Your Ref: OWPC5244
Our Ref: A/10/15/HH 28-01-2015
Please ask for:
Mrs A Gardner

2 No. detached houses with garages. This is a Departure from the Development Plan.
Land at West Drive Ham Manor Estate Angmering

Thank you for your internet representation made on 25th March 2015 which has been recorded as '**an objection**' with the comments as follows:

ELEVATIONS
PLOT 1

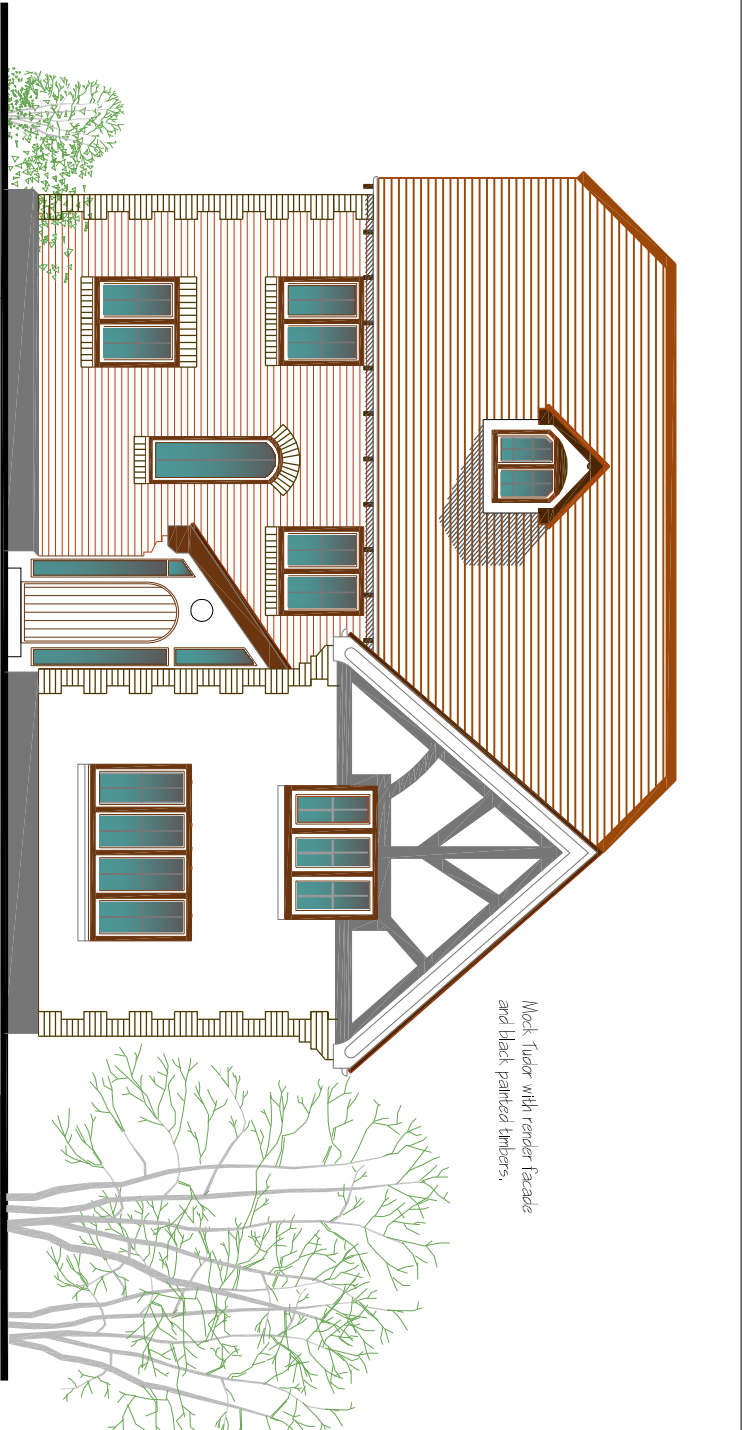
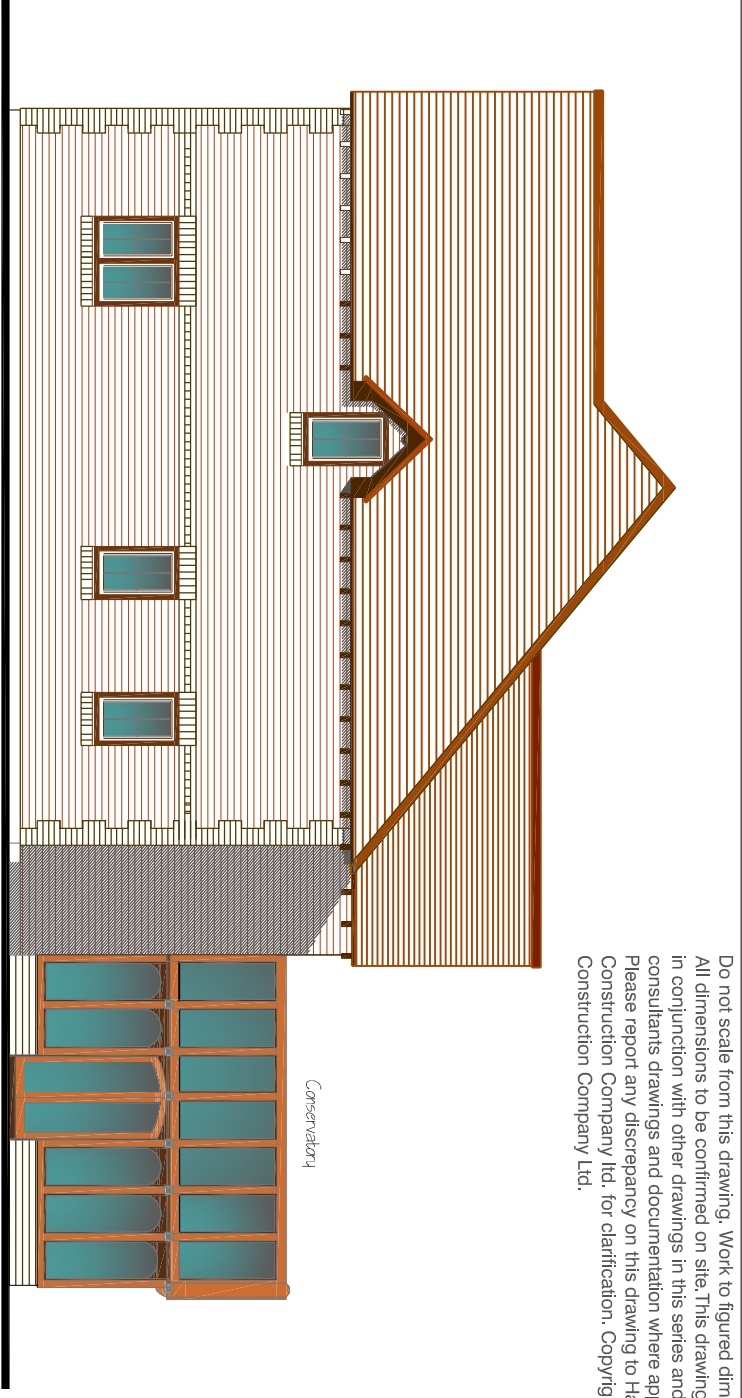
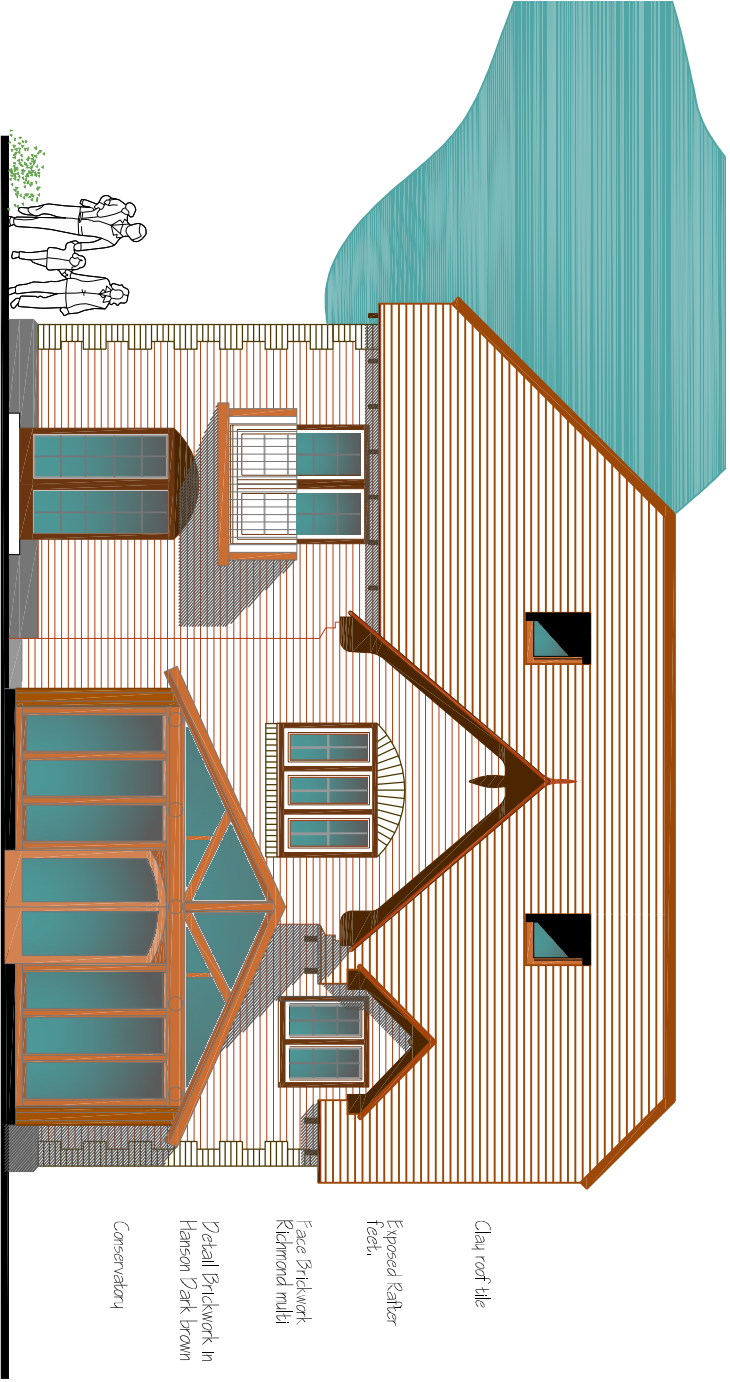
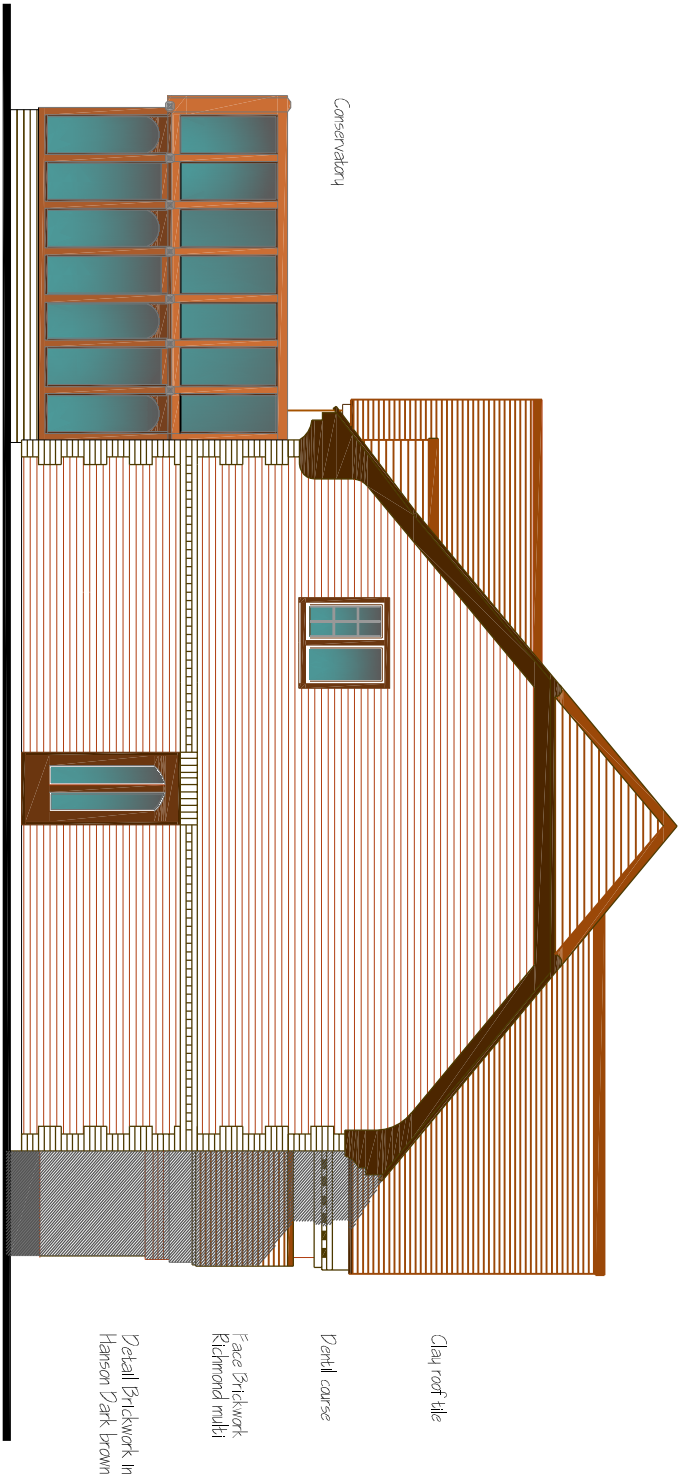
The plot itself is markedly raised in comparison to neighbouring properties, and the construction of a pair of 2.5 storey properties on it would mean the rooflines would not be comparable to typical heights of existing buildings in the immediate surrounding area, contrary to the Angmering Neighbourhood Plan Policy HD5: Build Form.

The new buildings would dominate the area and be overbearing, particularly to the properties to the north and east side of West Drive, and with windows overlooking them, severely intrude on the privacy of these residents.
